**From:** Contact Centre (CRM) <contact@ribblevalley.gov.uk>  
**Sent:** 21 February 2025 18:01  
**To:** Planning  
**Subject:** Planning Application Comments - 3/2024/1016 FS-Case-689709053

**Planning Application Reference No.:** 3/2024/1016

**Address of Development:** 1-7 The Picture House George Street Whalley BB7 9TH

**Comments:** Objection to 1-7 The Picture House George Street Whalley BB7 9TH

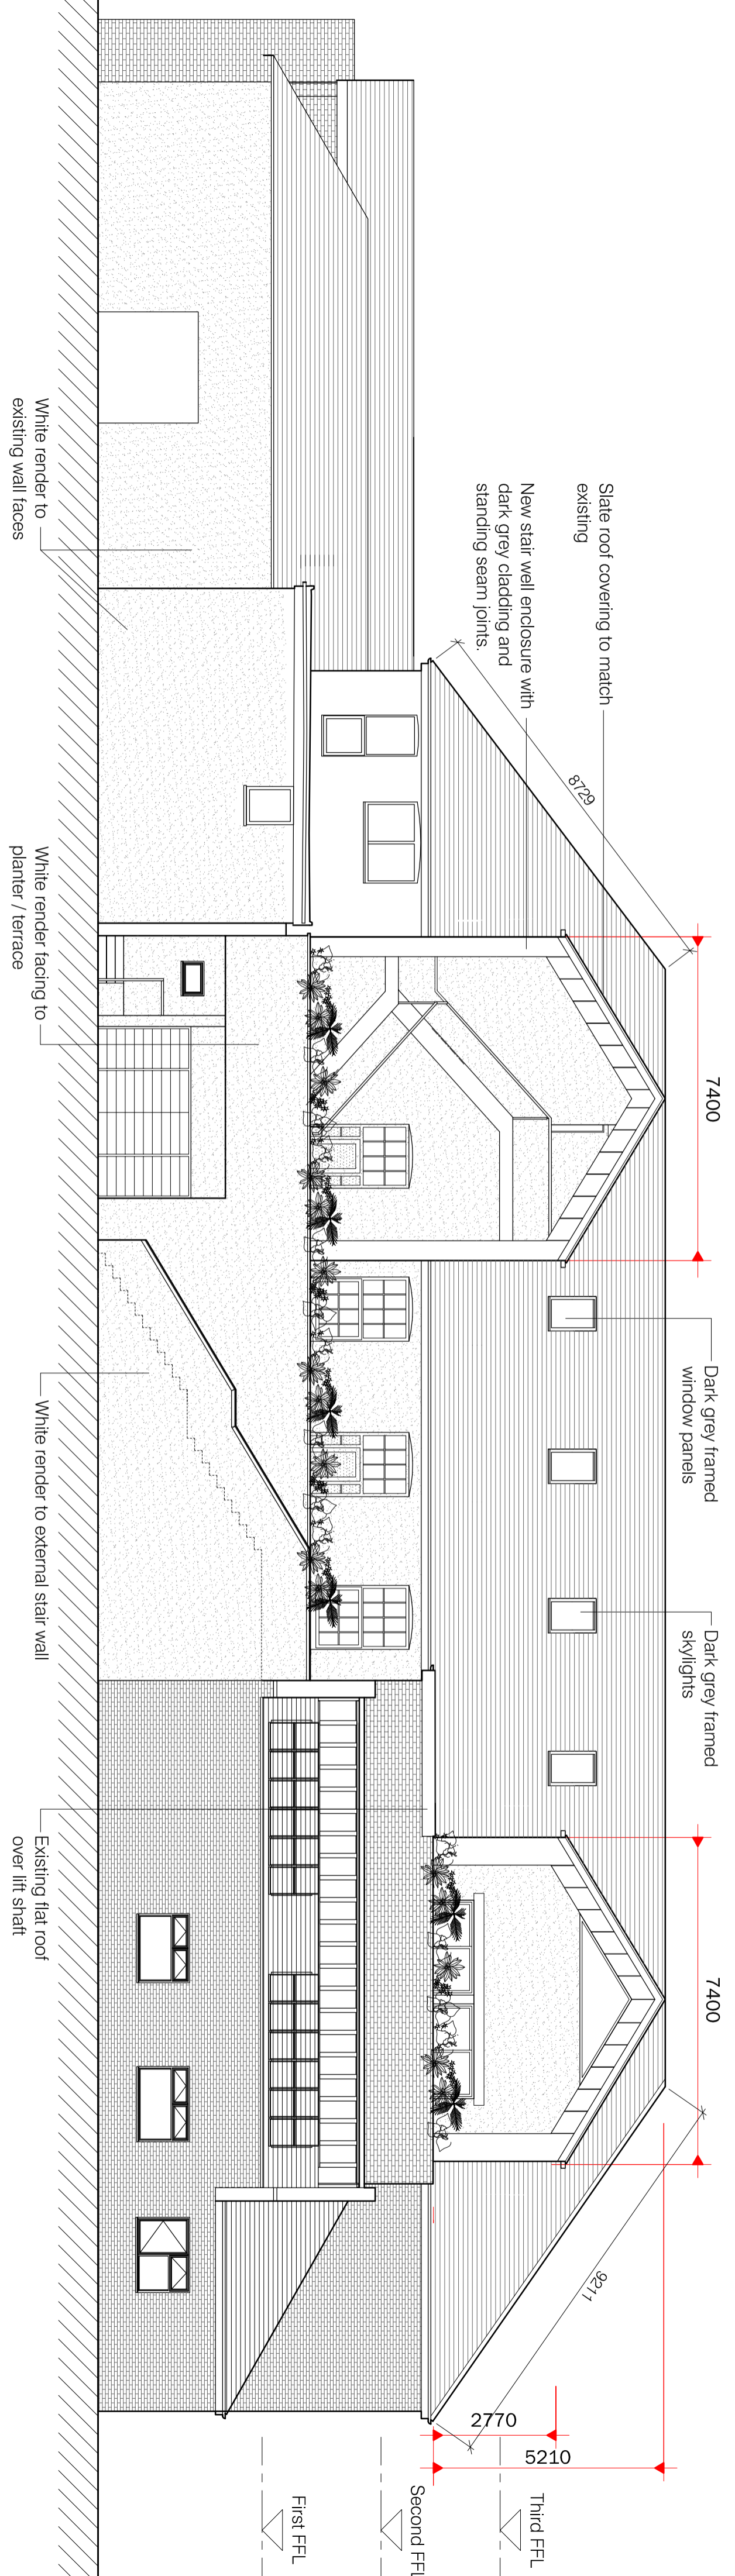
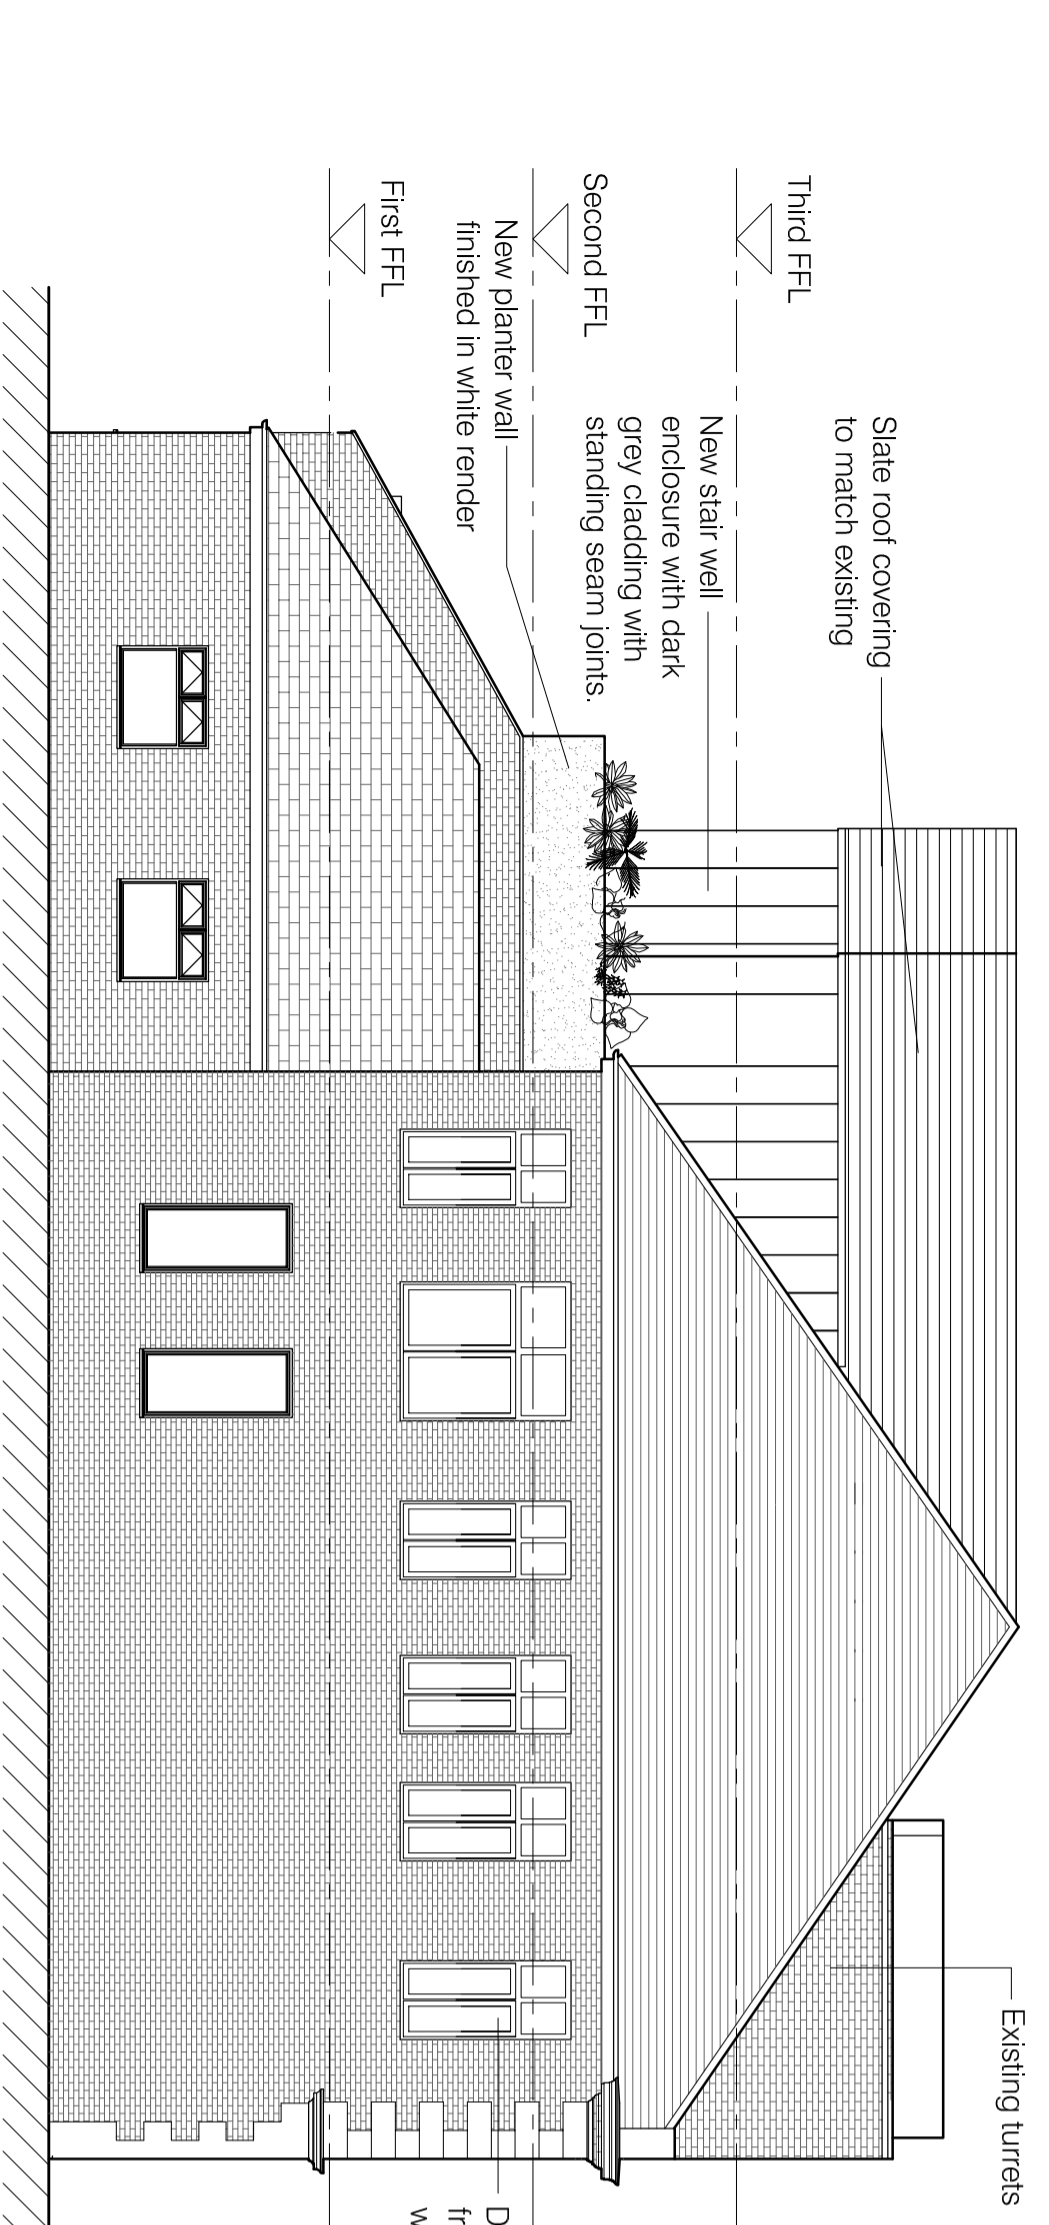
It is re-assuring to hear that 'The applicants are aware that there are differences in the "as built" development which are inconsistent with the original approval', but simply incorrect that they 'believe that these are of a minor nature within the context of the overall scheme'. Changes made to the Rear Elevation are major changes.

If the 'as built' Rear Elevation is the result of 'The applicants and their architect, agent have spent some considerable time and effort including abortive application submissions in attempting to resolve this situation' then this surely cannot be accepted as an explanation for the resultant major omissions and alterations.
